CONSULTEE RESPONSE (Arun District Council - Arboriculturist)

Reference: BE/16/25/RES

Proposal: Approval of reserved matters following outline consent BE/150/22/OUT comprising of 3no. units within Class B2 and/or B8 of the Use Classes Order (including ancillary office provision) with associated enabling works, parking, landscaping and sustainable drainage system with access off Newlands Road. This application is in CIL Zone 4 (Zero Rated) as other development.

Location: Land at Oldlands Farm, Newlands Road, Bognor Regis, PO22 9NN

Drawing file: BE_16_25_RES / Drainage Layout1.pdf

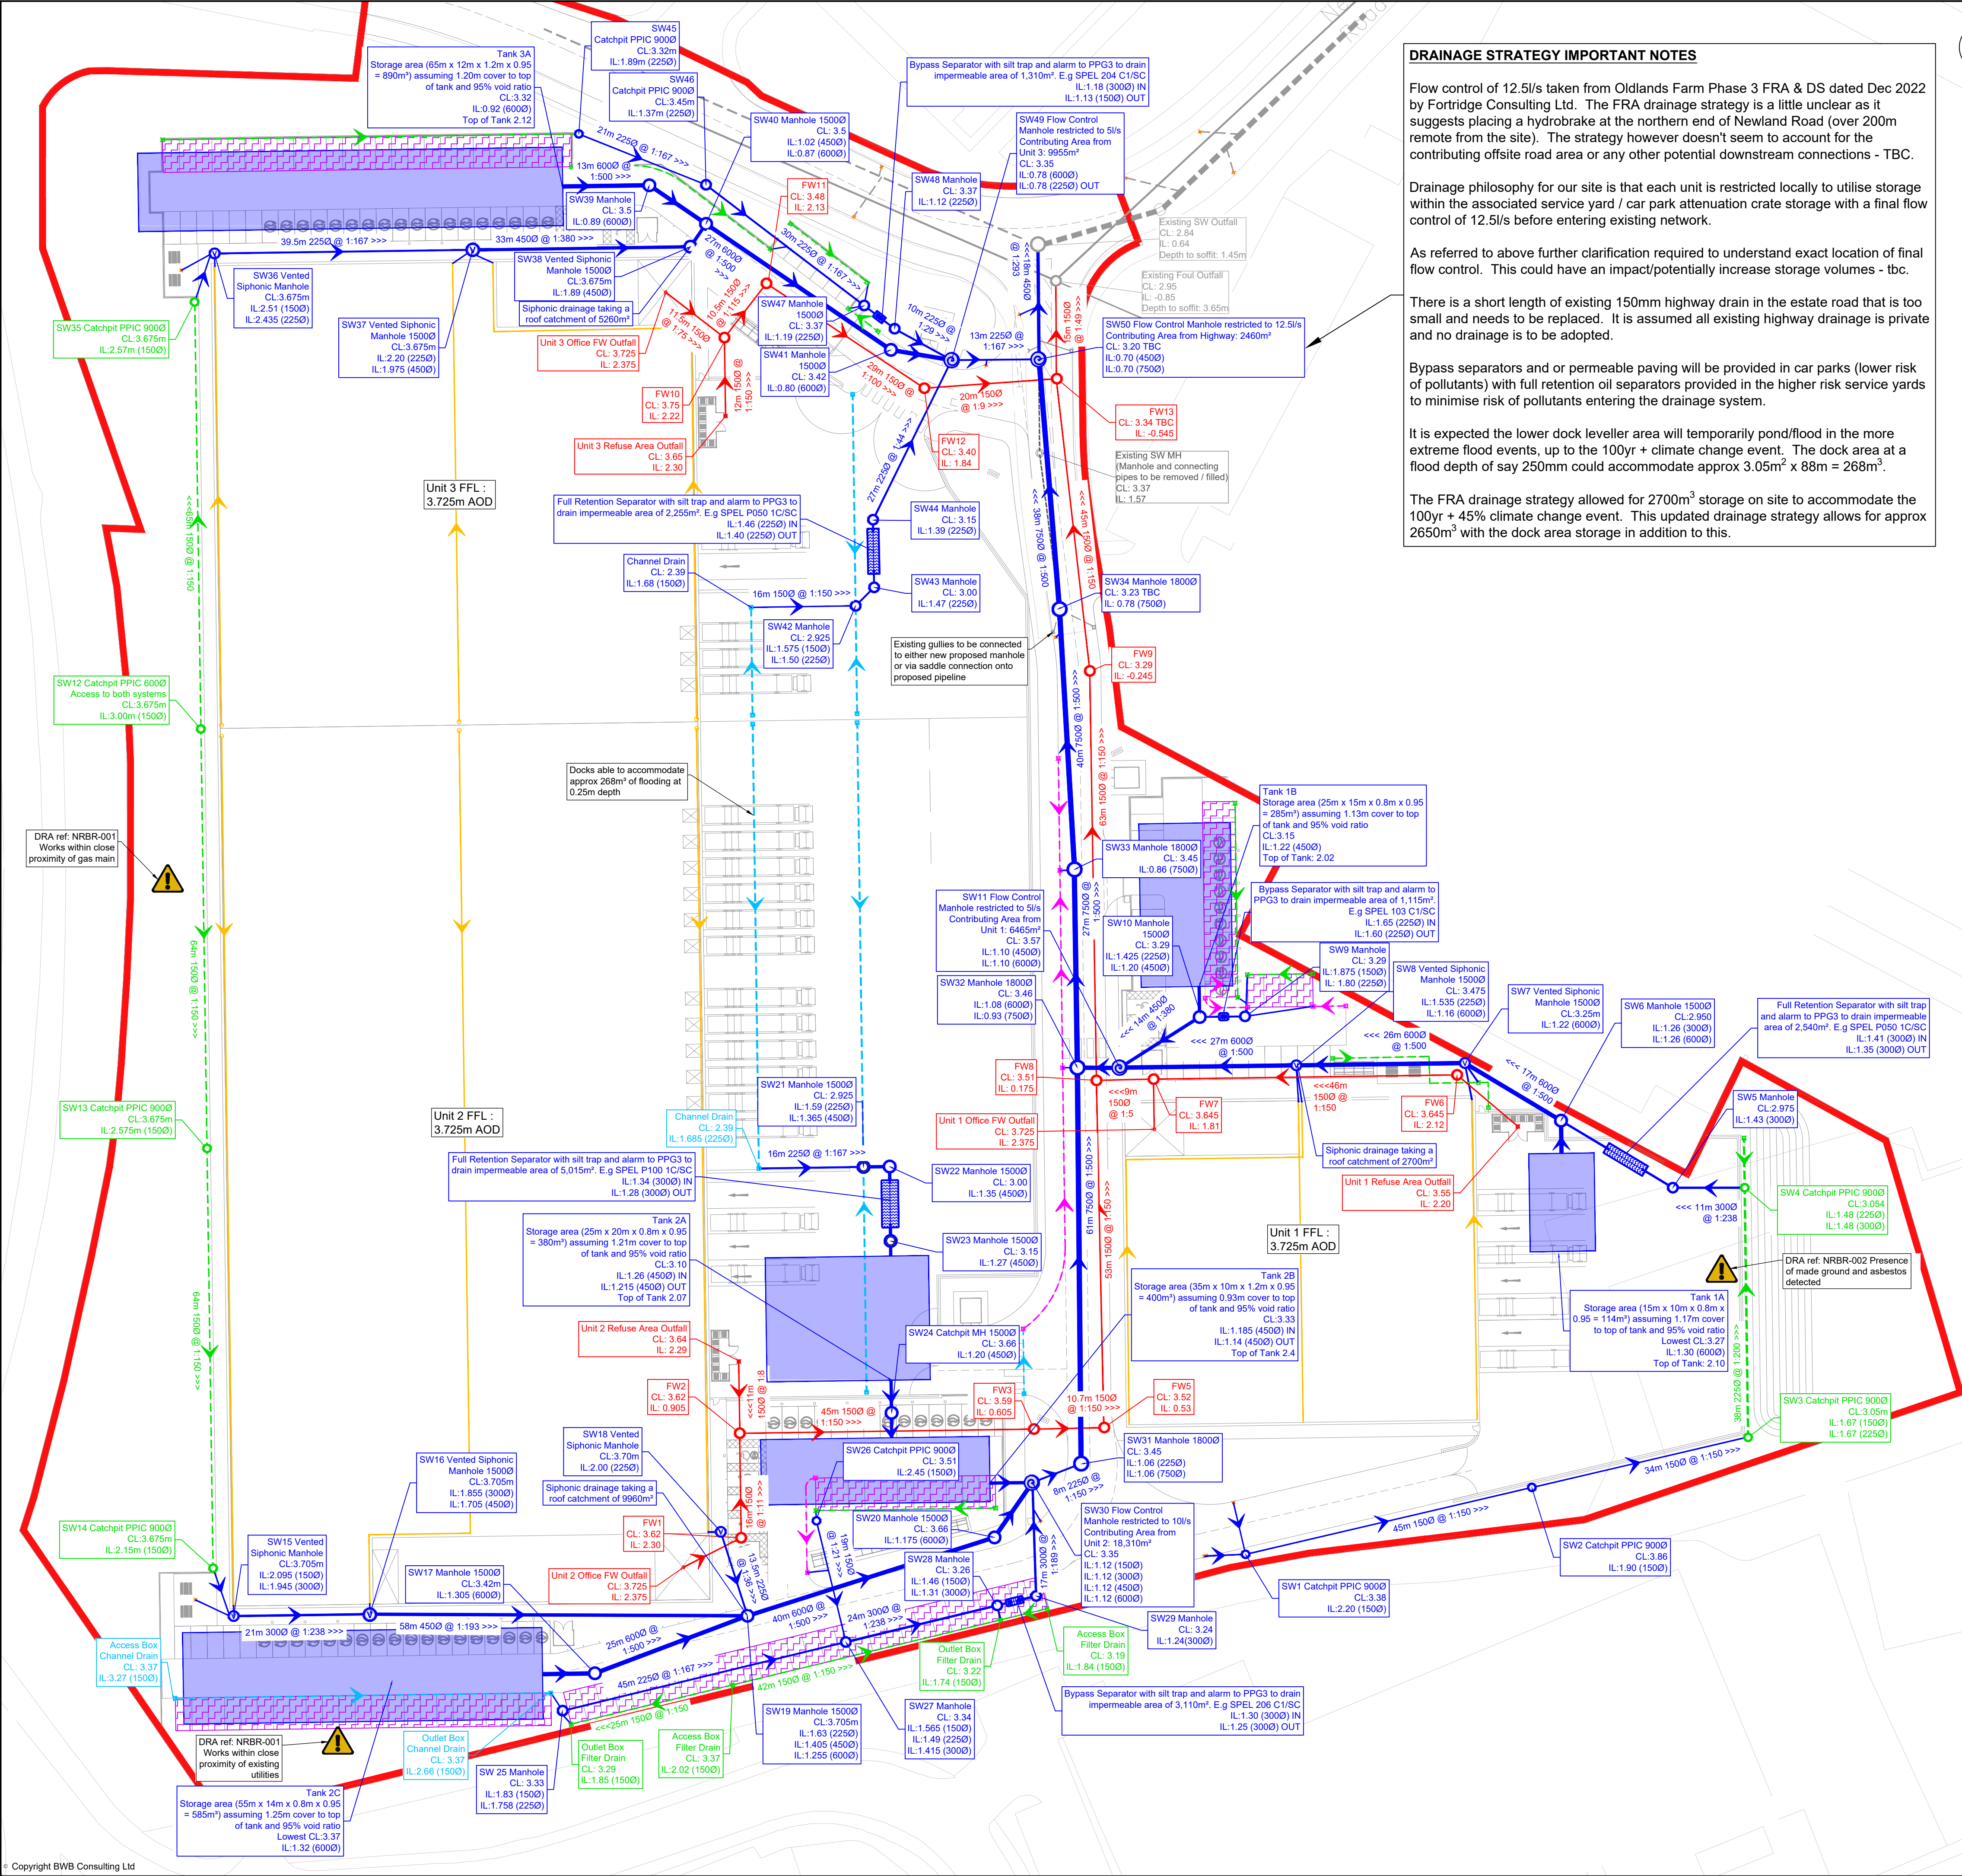
There does not appear to be an approved surface water drainage (and foul water sewer) strategy for the site. This fundamental element of the design ought to be addressed to our satisfaction in association with layout proposals, so that we are not subsequently held hostage to flood mitigation measures which could then impact heavily on retained trees/landscape plans.

The surface and foul water drainage layout reveals multiple areas of potential conflict between proposed utility apparatus and existing vegetation.

I draw attention to the nominal root protection areas (RPA) of retained trees and their growth potential as obvious constraints to the siting of any SUDS feature, soakaway or introduction of subterranean utility apparatus. The provision of appropriate buffer/easement around such features must also take into account that growth potential (roots), to limit the risk of damage occurring during future maintenance of the same, from compaction/contamination of the soil structure.
